Application number: 2025/92713	
What is the application for?:	Reserved matters application pursuant to outline permission 2023/92079 for erect
Address of the site or building:	Rear of, 23 to 43, Moor Lane, Gomersal, Cleckheaton, BD19 4LF
Postcode:	LS10 1NB

Type of comment: An objection	
Do you wish your comments to be published on the website anonymously?	<input checked="" type="checkbox"/> Yes
General Comments re Drainage and Flood Exceedance Routes General [id 1107227] Size: 1008KB 30/09/2025 - PV2511-APP-92-XX-DR-C-2501-P01 -	
<p>When Summerdale was built over 30 years ago and towards the end of the construction period, there was considerable flooding to the gardens of house numbers 15, 17, 19 and 21.</p> <p>To prevent any reoccurrence the contractor laid land drains along the boundary between the field and gardens of house numbers 19 and 21.</p> <p>This was then connected to a gully in the road outside number 25 and this is often running with water.</p> <p>Whilst no serious flooding has reoccurred since then, these two properties do suffer from occasional standing water in the gardens after heavy rainfall.</p> <p>This brings me onto the fact that this latest application by the

Private Drainage

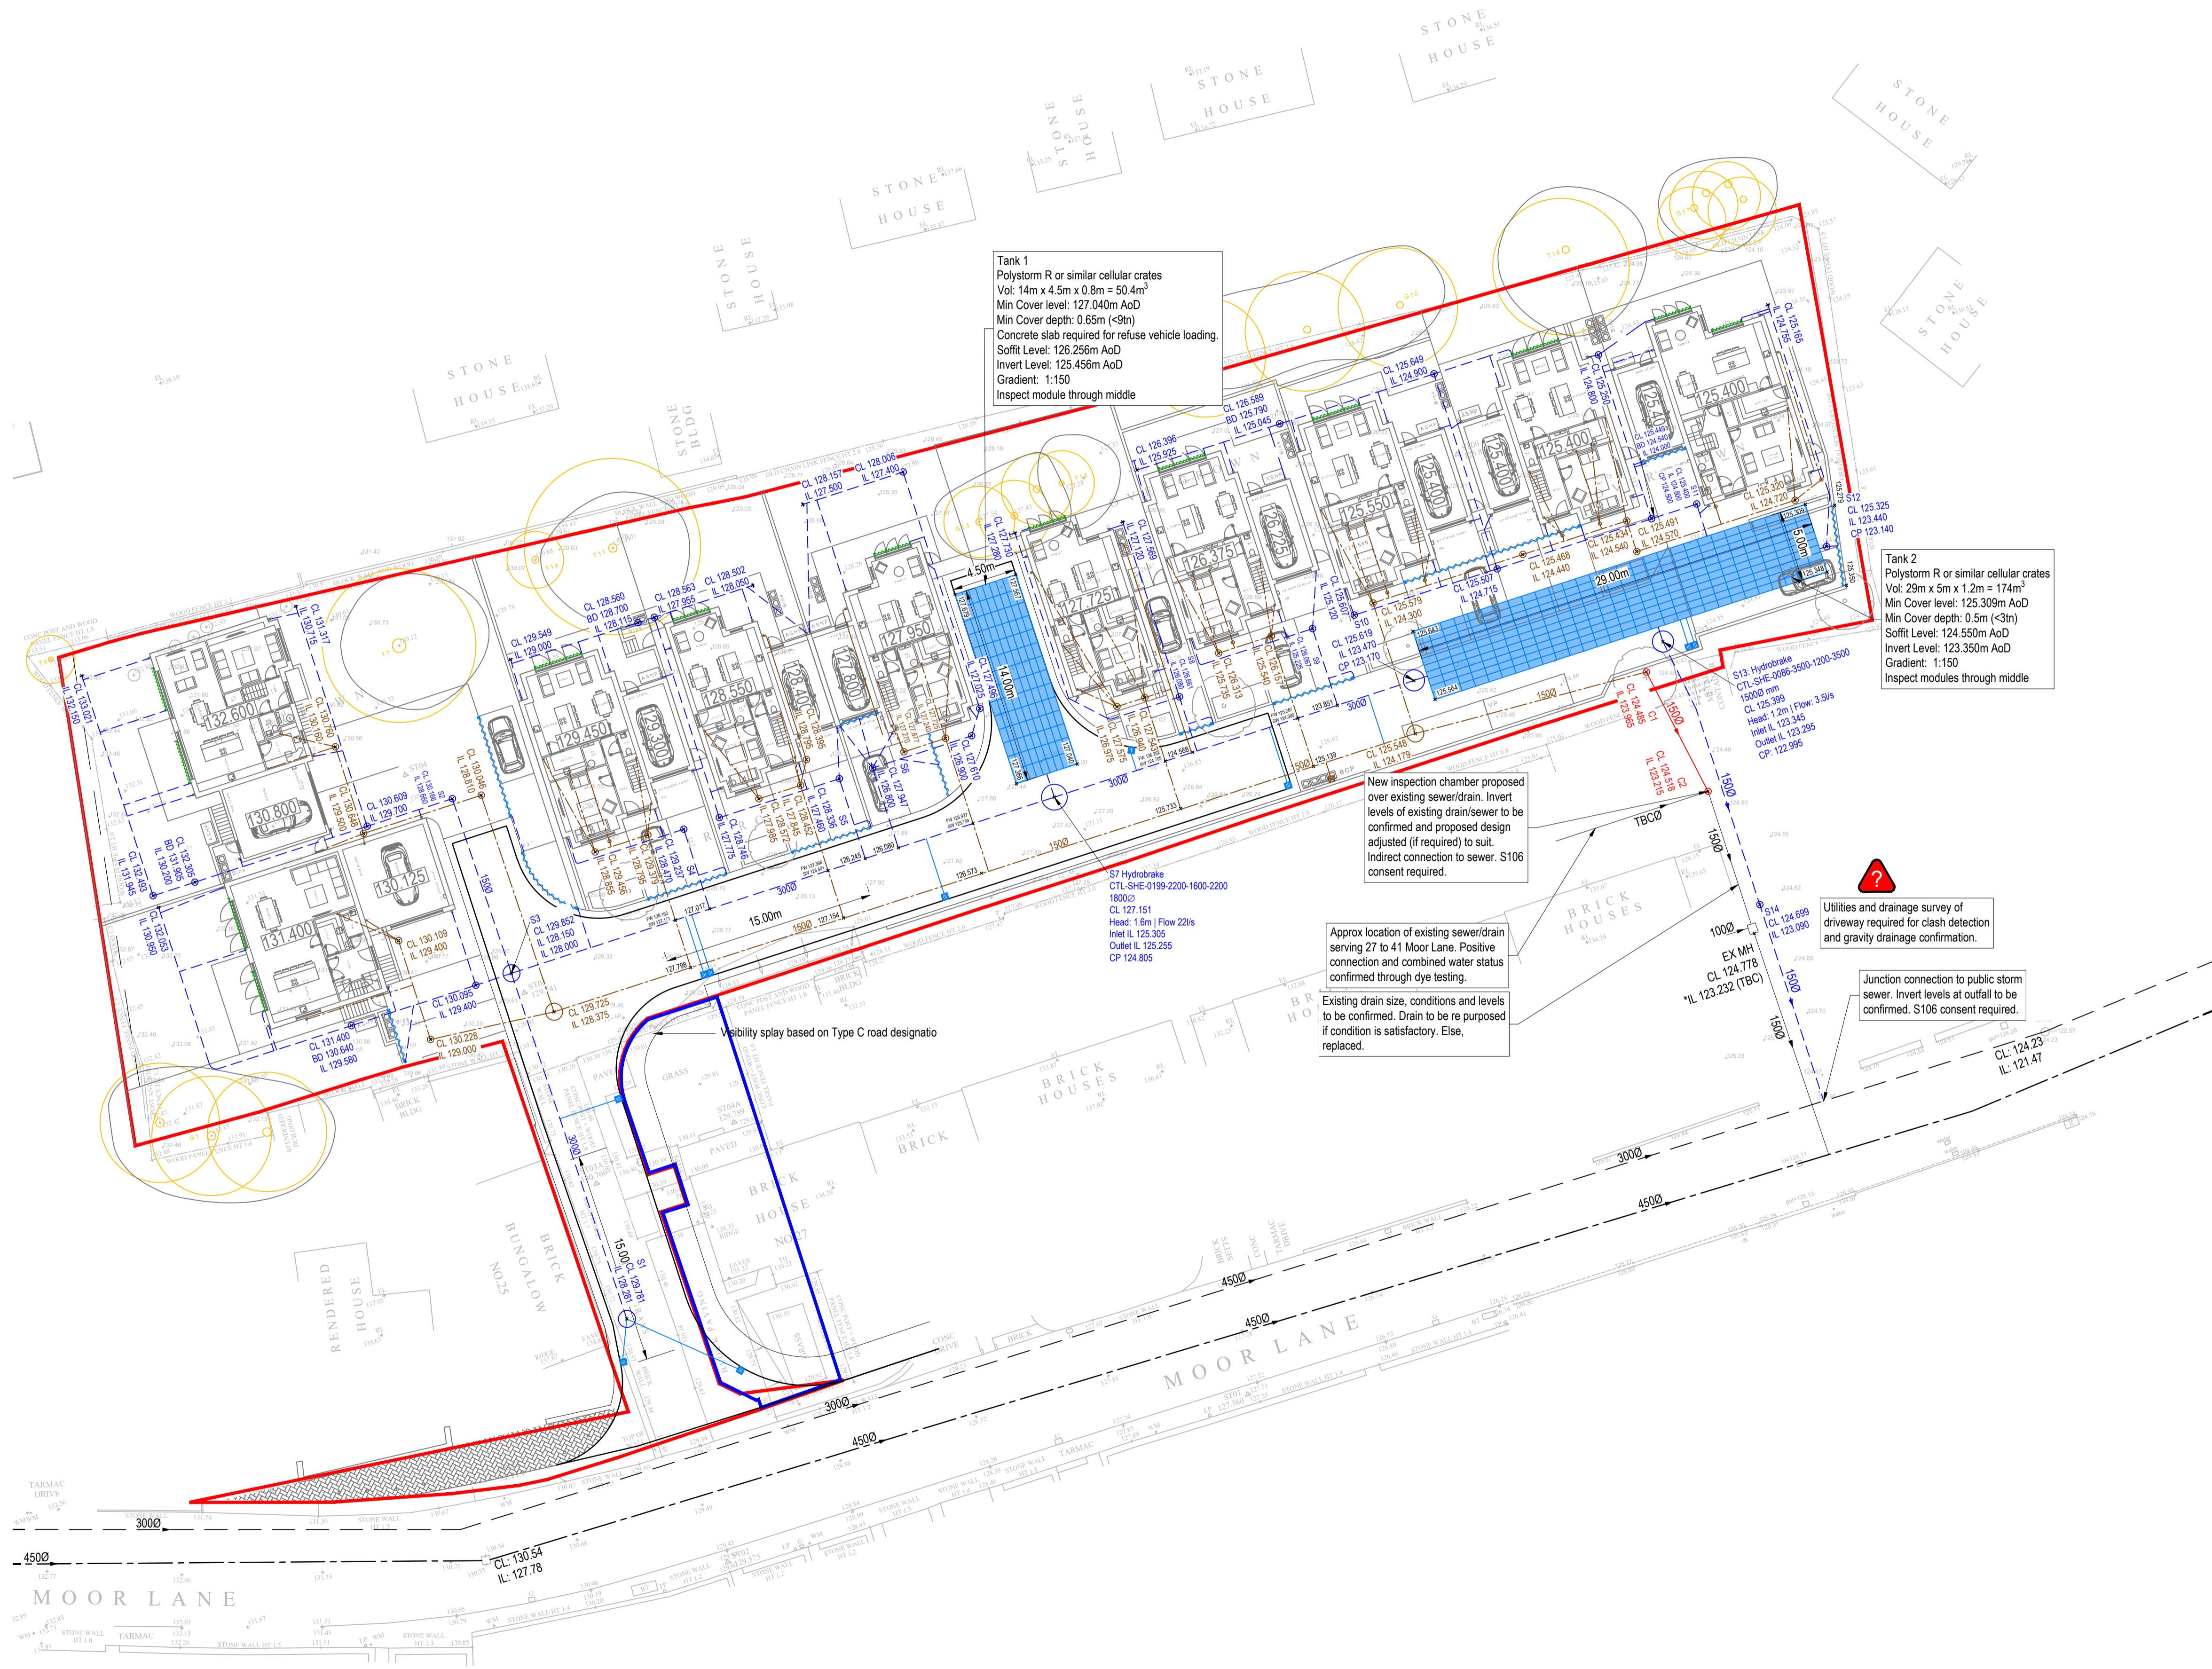
Below is an extract re Flood exceedance guidance which seems to suggest that the proposals are not in line with the criteria.

In view of the fact that negotiations took place between the council and original developer to facilitate drainage from the site to pass through the council owned garden of number 41 Moor Lane ( current ownership unknown ) it would be more appropriate for the Flood exceedance route to be directed in this direction also. Any above ground pathways and channels etc, could be formed at the same time as the underground drainage was being carried out.

Directing any flood water in this direction would have less impact on surrounding properties as it would flow directly into Moor Lane itself, and not the Summerdale or Moor Lane properties.

On the question of drainage generally, the plans show a single 150mm diameter drain pipe to take both foul and surface water drainage from the south east corner of the site, and as stated before this is to run through the garden of No 41 Moor Lane, before being connected into the existing 450mm Combined Drain in Moor lane.

I'm surprised that only one 150mm diameter drain is taking both the Surface water and Foul water from the development site, because the previous application allowed for the surface water drain to connect into the combined main drain at the South East end of the development, along with a separate foul water drain connected into the same combined main drain at the South West end of the site.

In view of the potential risks of flooding, the need to install two Underground Cellular Crate water reservoirs to manage water flow etc, and the alarming area of Impermeable areas, I would have thought that it was imperative that the Foul and Surface water be kept separate until they reach the main drain in Moor Lane. This would then minimise the risk of serious blockages occurring and the whole system backing up.
